**From:** Jean Fraser  
**To:** Veroneau, Vin  
**CC:** Andrews, Deb; Errico, Thomas; Schmuckal, Marge  
**Date:** 8/25/2014 3:50 PM  
**Subject:** Signage permits at Marriott Courtyard  
**Attachments:** Permitting process note for Vin 321 Commercial - Copy.pdf; Signage & Wayfinding Plan Marriot Portland 05-12-14.pdf

FOUNDRY  
LANE

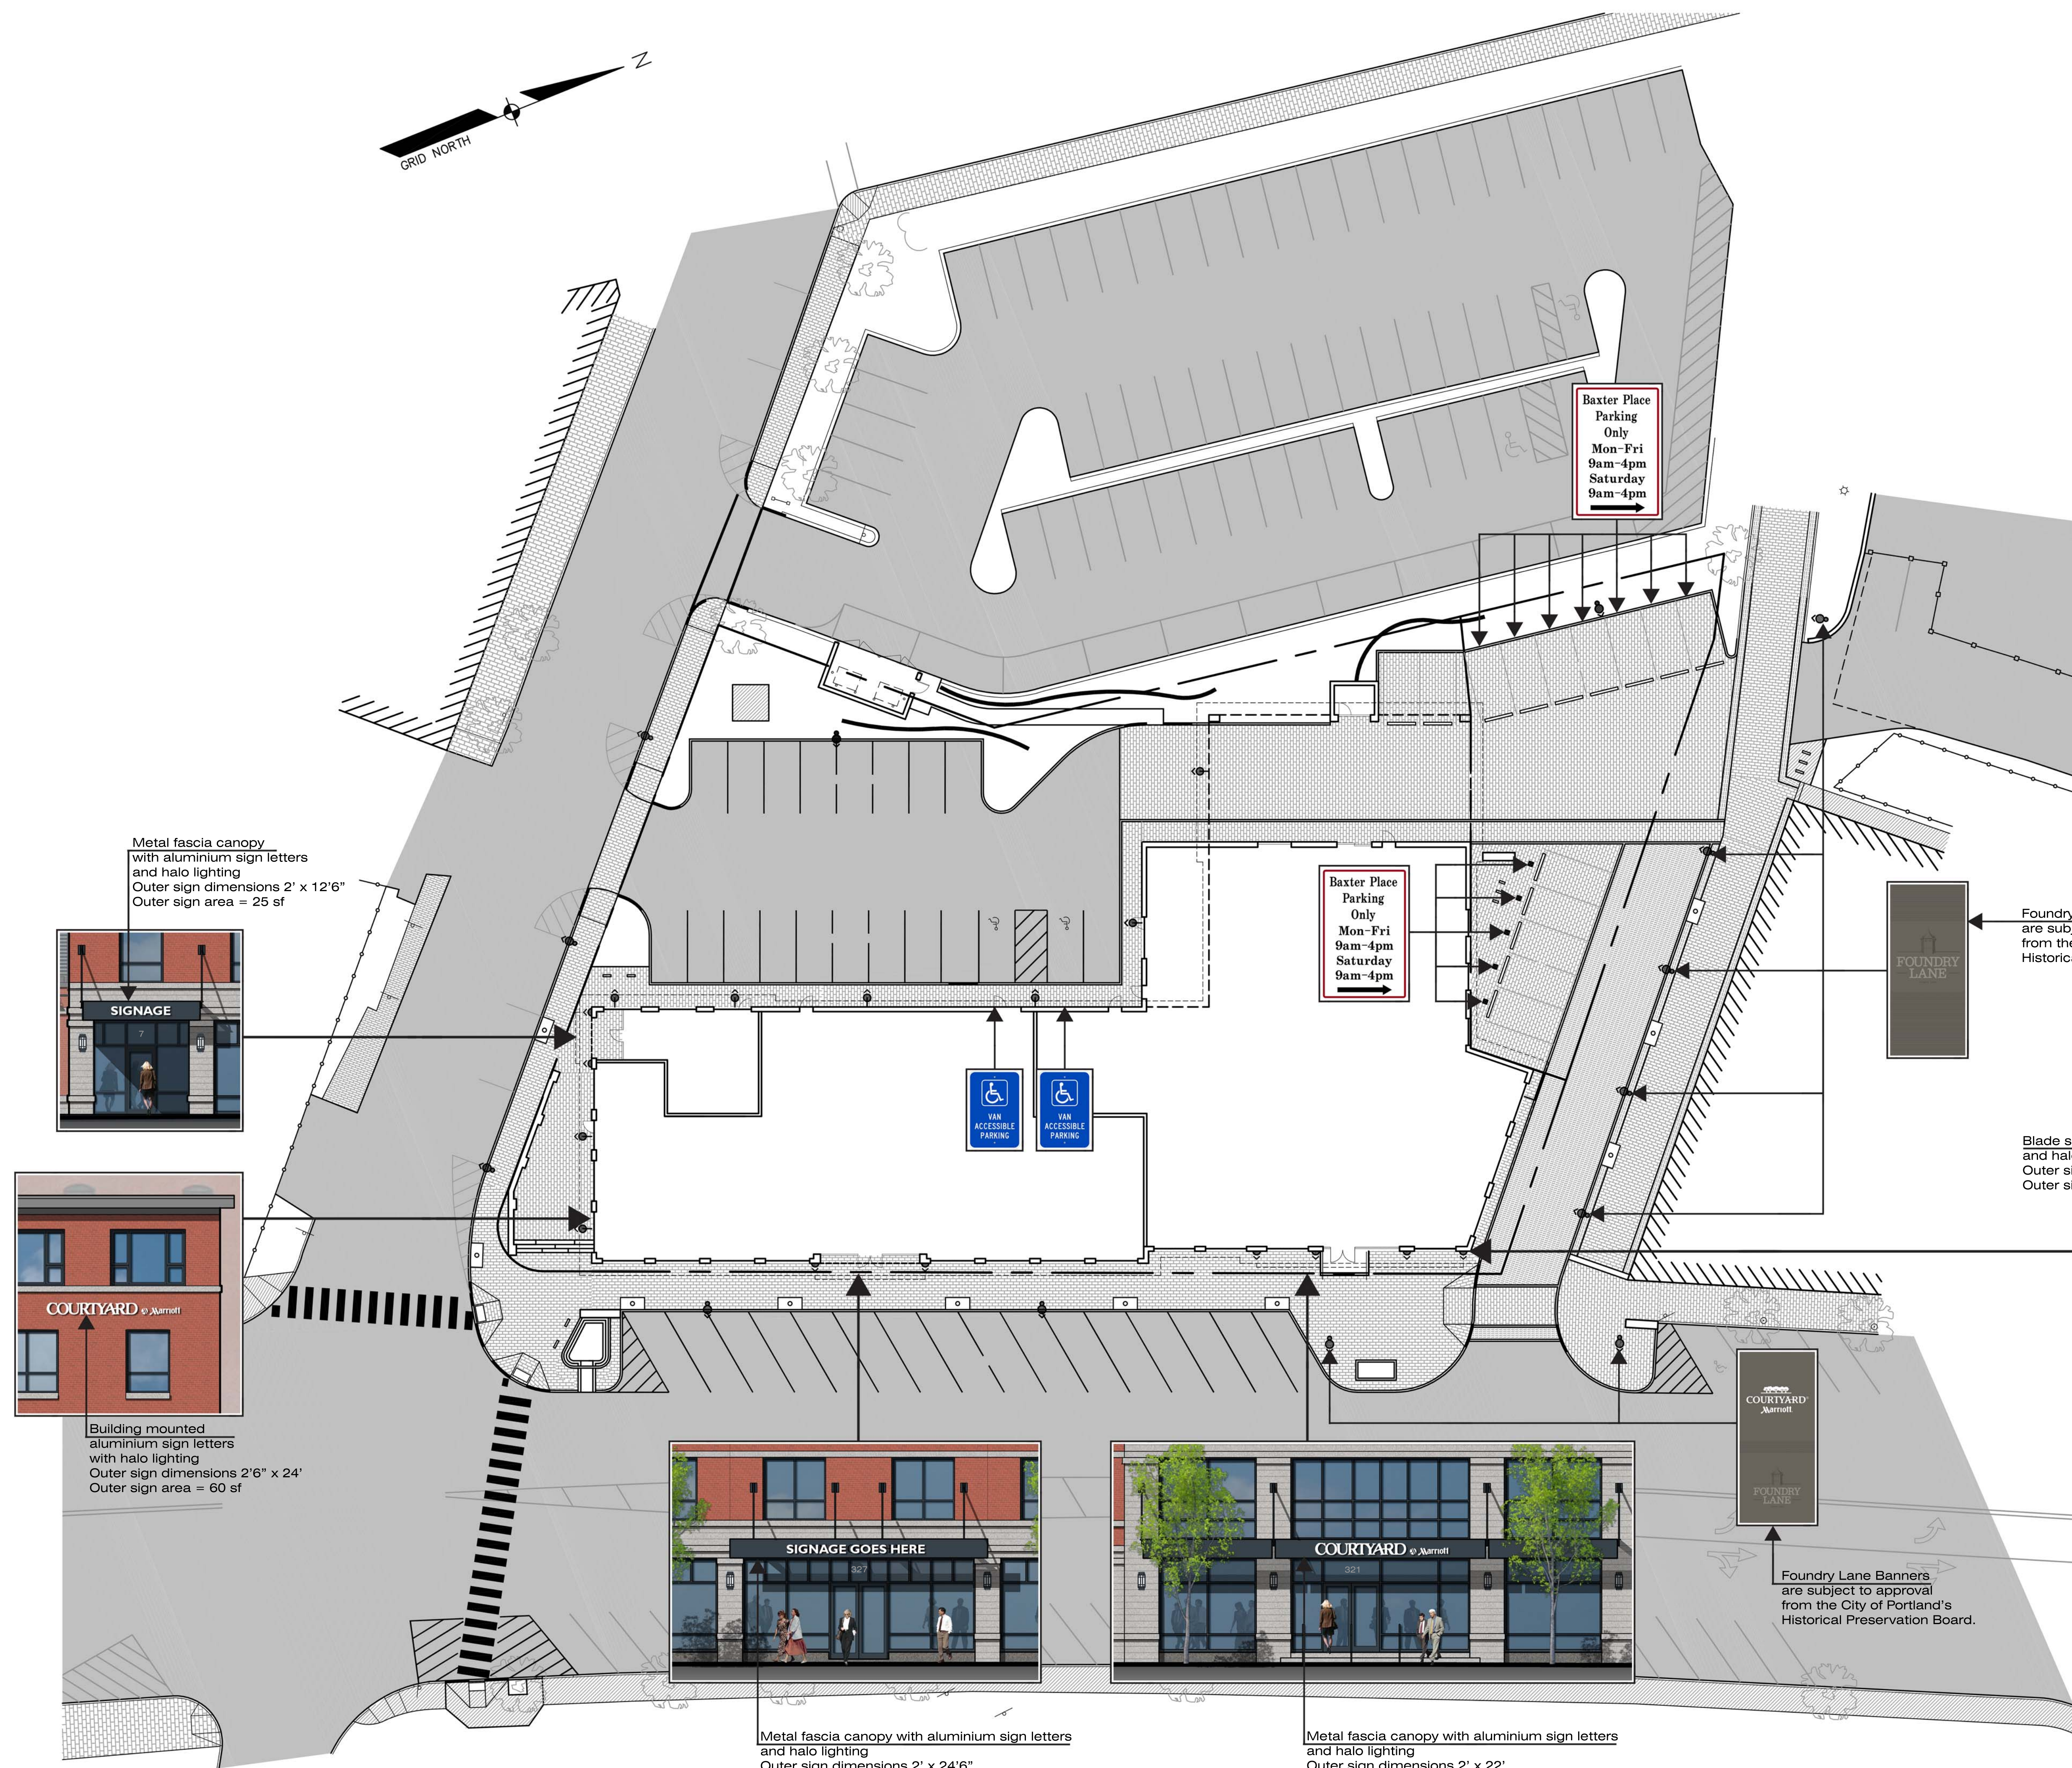
In summary, you clearly need a sign permit for the banners in Foundry Lane that have a "commercial" content eg "Marriott". The ordinance does say banners do not need a permit in this location, subject to their content not being commercial signage (and where it is commercial signage it gets added in to the total allowable for the site). All those along Foundry Lane potentially also have a directional/historic contribution and this will be a factor if they need to be reviewed under Site Plan.

The valet parking "portable" sign also definitely needs a permit and a license (details on the attached table).

Any on the light columns that say "Foundry Lane" in the ROW will probably be OK as these are in many places in Portland and these are in lieu of a street sign so are "directional" and would be considered to be put up on behalf of the City (but I will need to get DPS more involved- but first need size and design and mounting height; also Deb was going to send you some dates and you might run the banner content by her so it has historical accuracy).

I suggest that you submit a sign permit to Marge Schmuckal, Zoning Administrator (copy to me so I can liaise with Marge and keep Tom and Deb in the loop) that includes:

1. The revised plan that is similar to attached, including the "portable" sign for the valet parking and all signs in Foundry Lane and abutting ROW areas
2. A table of the sizes and designs/wording of the banners cross-referenced to the plan
3. Copy of my table as background for reviewers
